SEARS REQUEST – STONE RIDGE QUARRY PROJECT – LOTS: 36 & 65 DP: 753200, LOT: 1 DP: 724372, PART LOT: 540 DP: 1207159, WALLAROO STATE FOREST, BALICKERA – SSD 10432

TfNSW have reviewed the Scoping Report for the proposed Stone Ridge Quarry Project, by Australian Resource Development Group P/L, dated February 2020. It is understood that the proposal be for a quarry with an extraction area to support the removal and transportation of 1.5Mtpa of material over a 30 year period.

Figure 3.2 Italia Road / Pacific Highway intersection

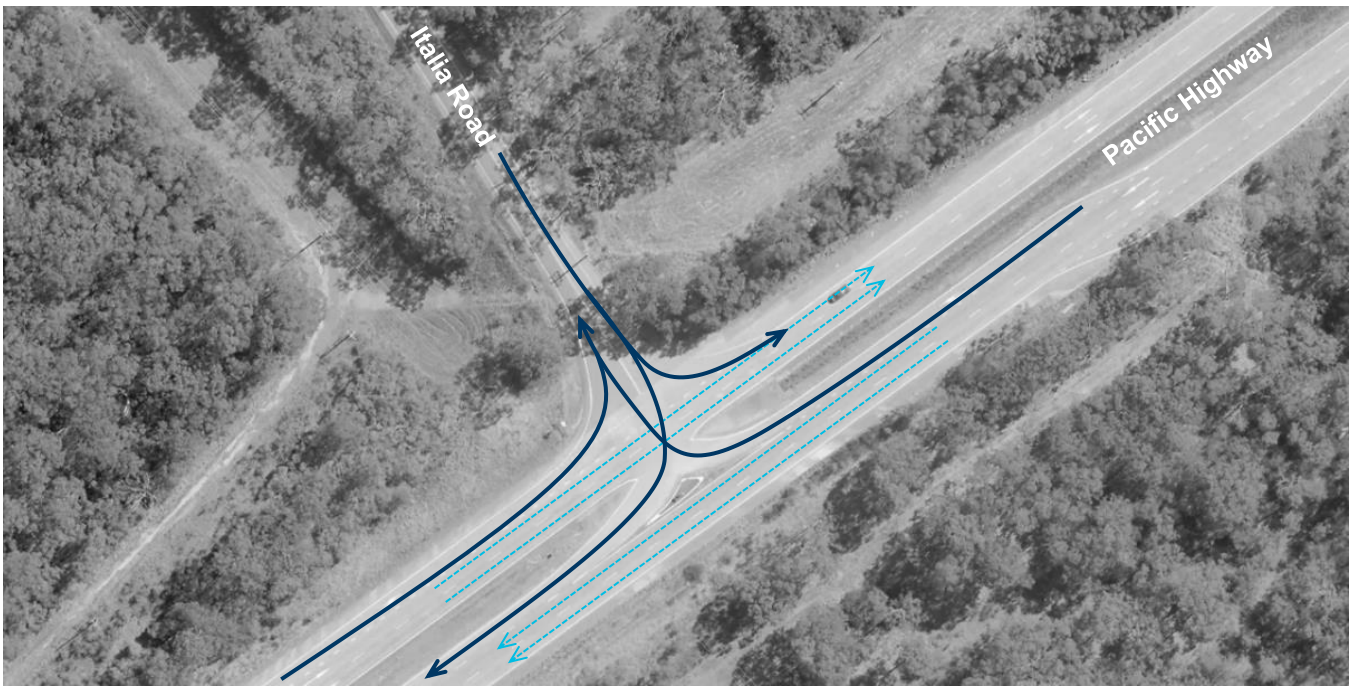
- Consideration of the impact on the Pacific Highway and Italia Road intersection from the increase in trips resulting from the construction and operation of the quarry. The traffic impact shall also include the cumulative traffic impact of other proposed and operating developments in the area.

- Traffic assessment and analysis of the Pacific Highway at Italia Road is to include, using SIDRA or similar traffic model, including:
 - Current traffic counts and 10 year traffic growth projections

- With and without development scenarios
 - 95th percentile back of queue lengths
 - Delays, degree of saturation and level of service on all legs for the relevant intersections

- Modelling data files for TfNSW review.
- Identify the necessary road network infrastructure upgrades that are required on both the local and classified road network for the development. **Comment - TfNSW raise concern regarding the increase in all vehicle usage of this intersection in its current form, and in particular heavy vehicle usage. TfNSW consider the ability for the intersection to accommodate additional vehicles is limited. Grade separation of the right turns should be considered to mitigate the impact of the development.**

Client	AUSTRALIAN RESOURCE DEVELOPMENT GROUP
Project	ARDG / ERS / BORAL - ITALIA ROAD ACCESS ARRANGEMENTS
Title	STRATEGIC CONCEPT DESIGN ALTERNATE OPTION 03
Original Size	A3
Drawing No:	22-19467-SK110
Rev:	A

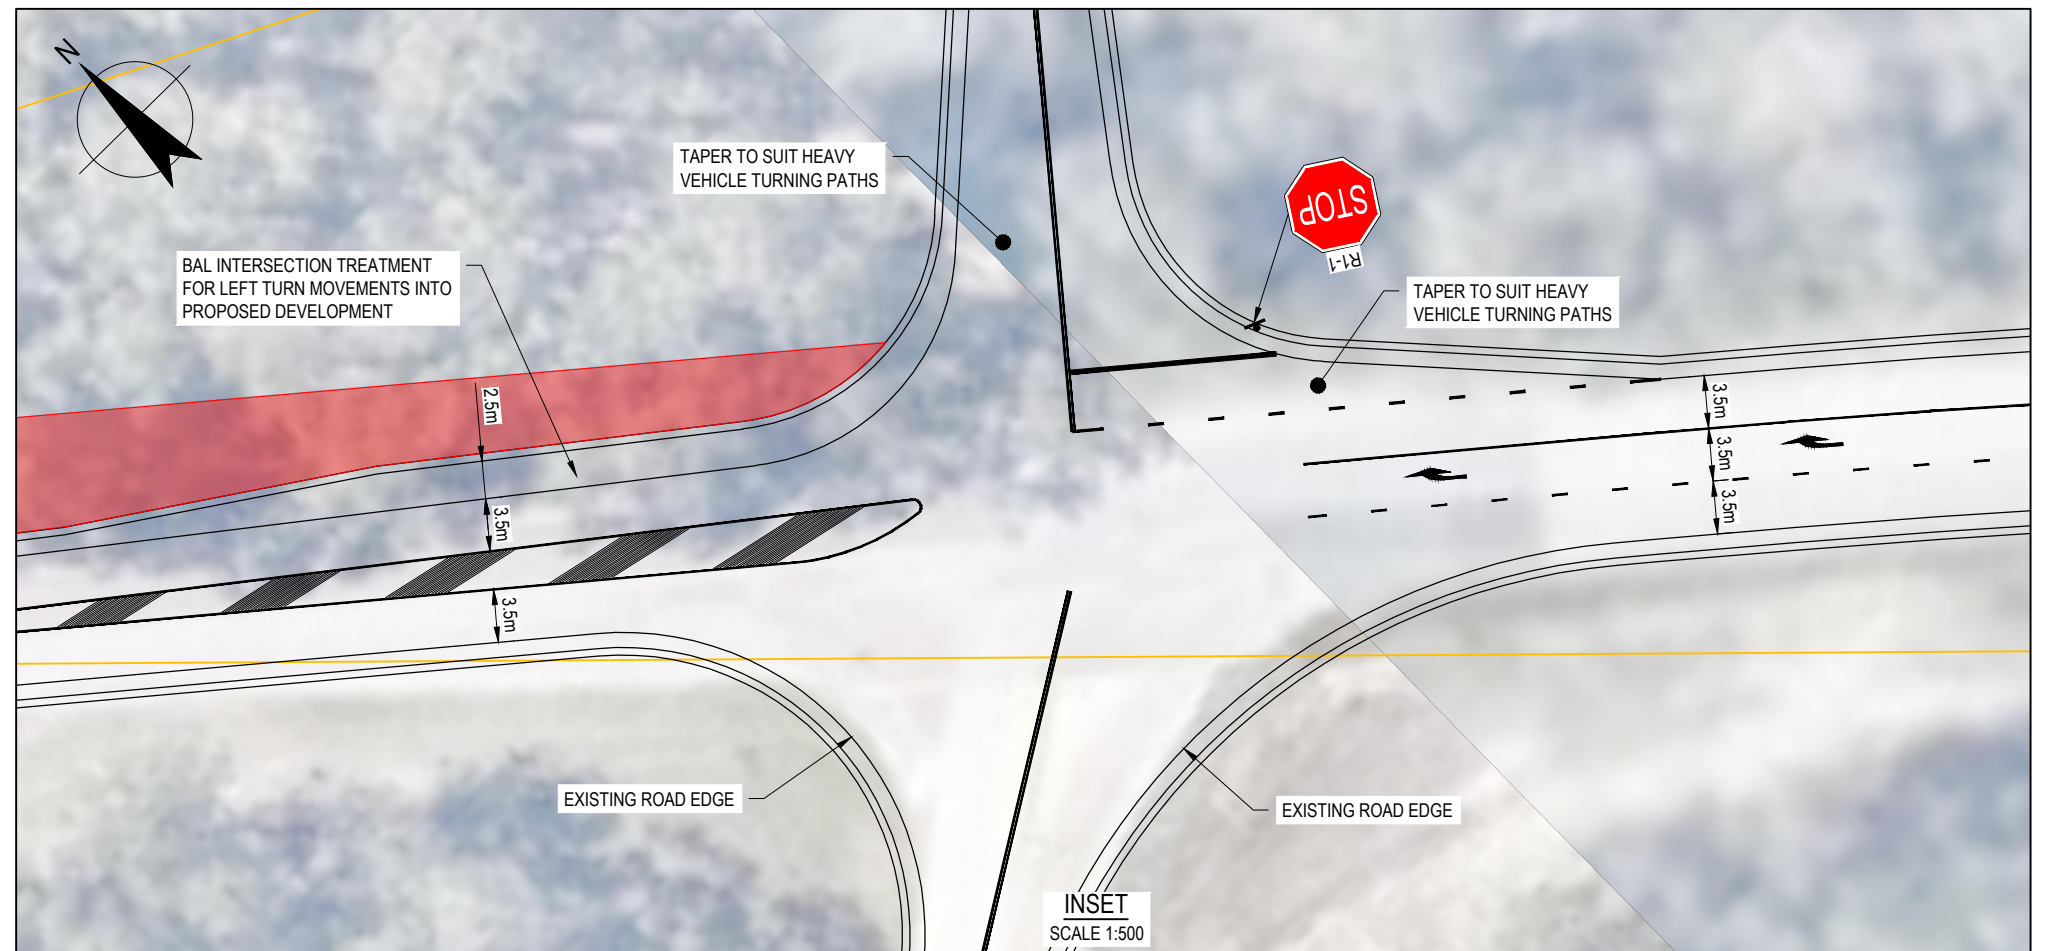
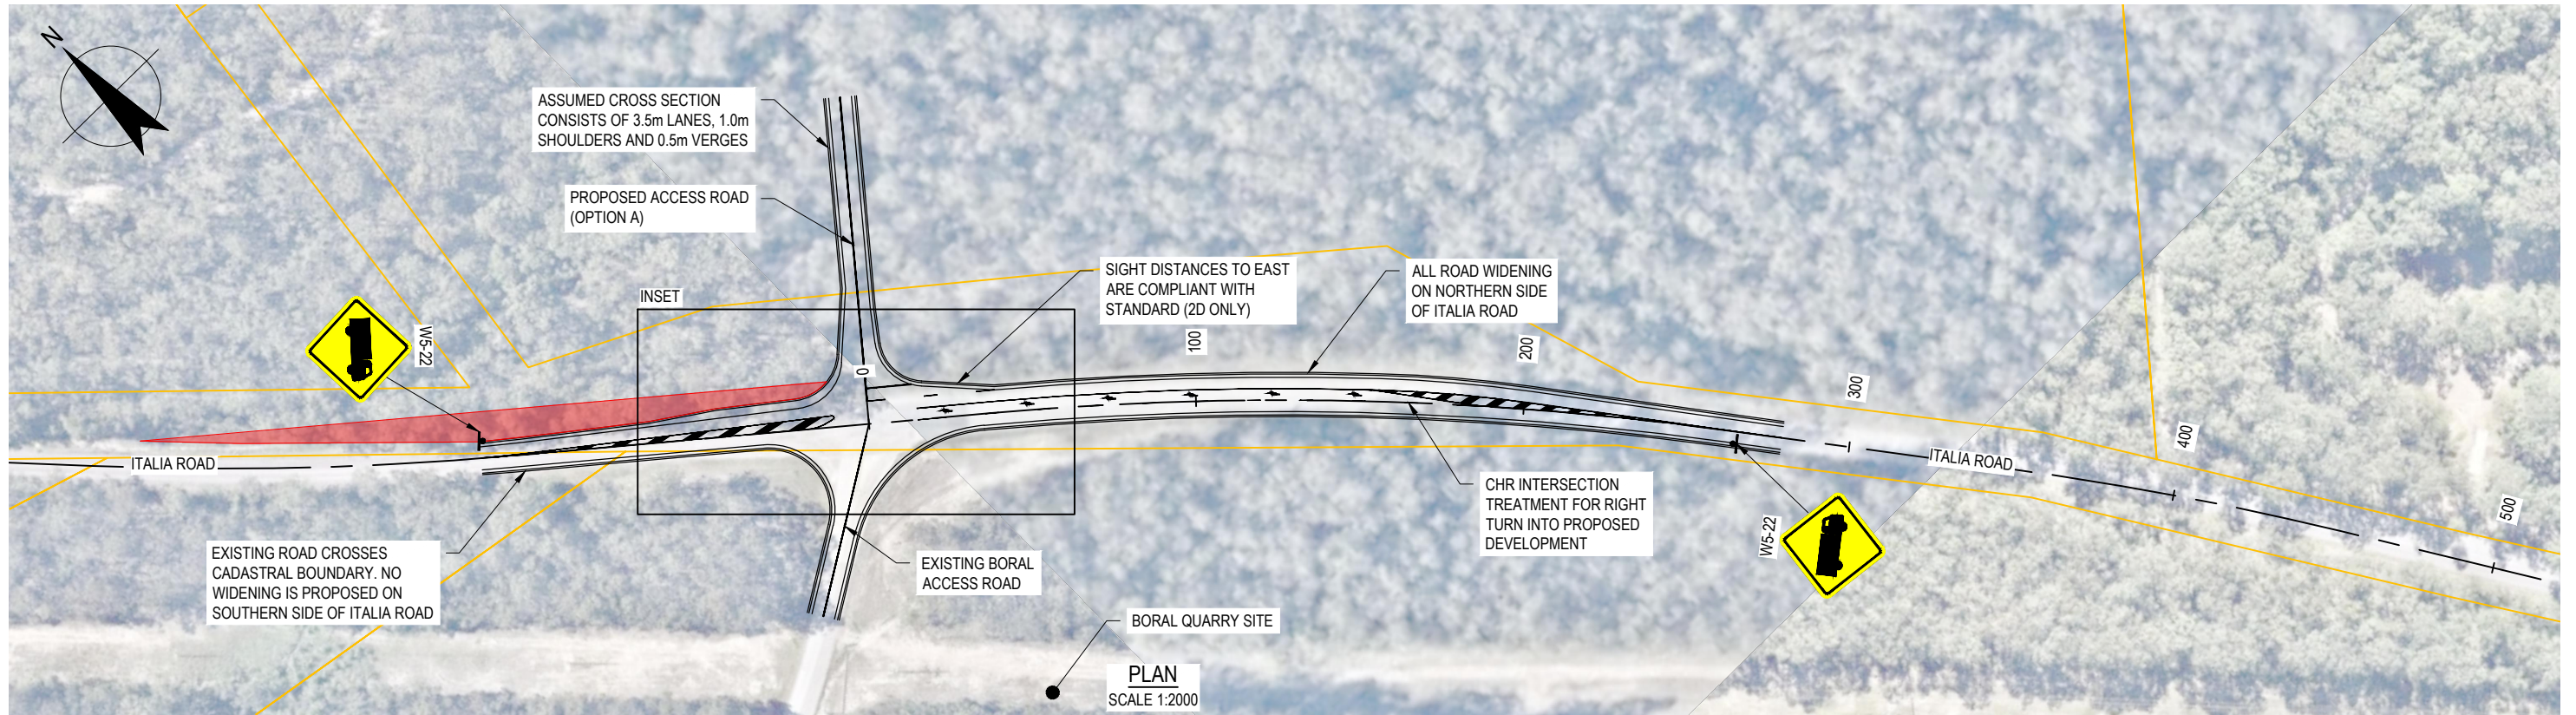
- Preliminary concept drawings shall be submitted with the EIS for any identified road infrastructure upgrades. However, it should be noted that any identified road infrastructure upgrades will need to be to the satisfaction of TfNSW and Council.
- Identification of funding mechanisms to deliver any required road infrastructure.
- Any other impacts on the regional and state road network including consideration of pedestrian, cyclist and public transport facilities and provision for service vehicles.
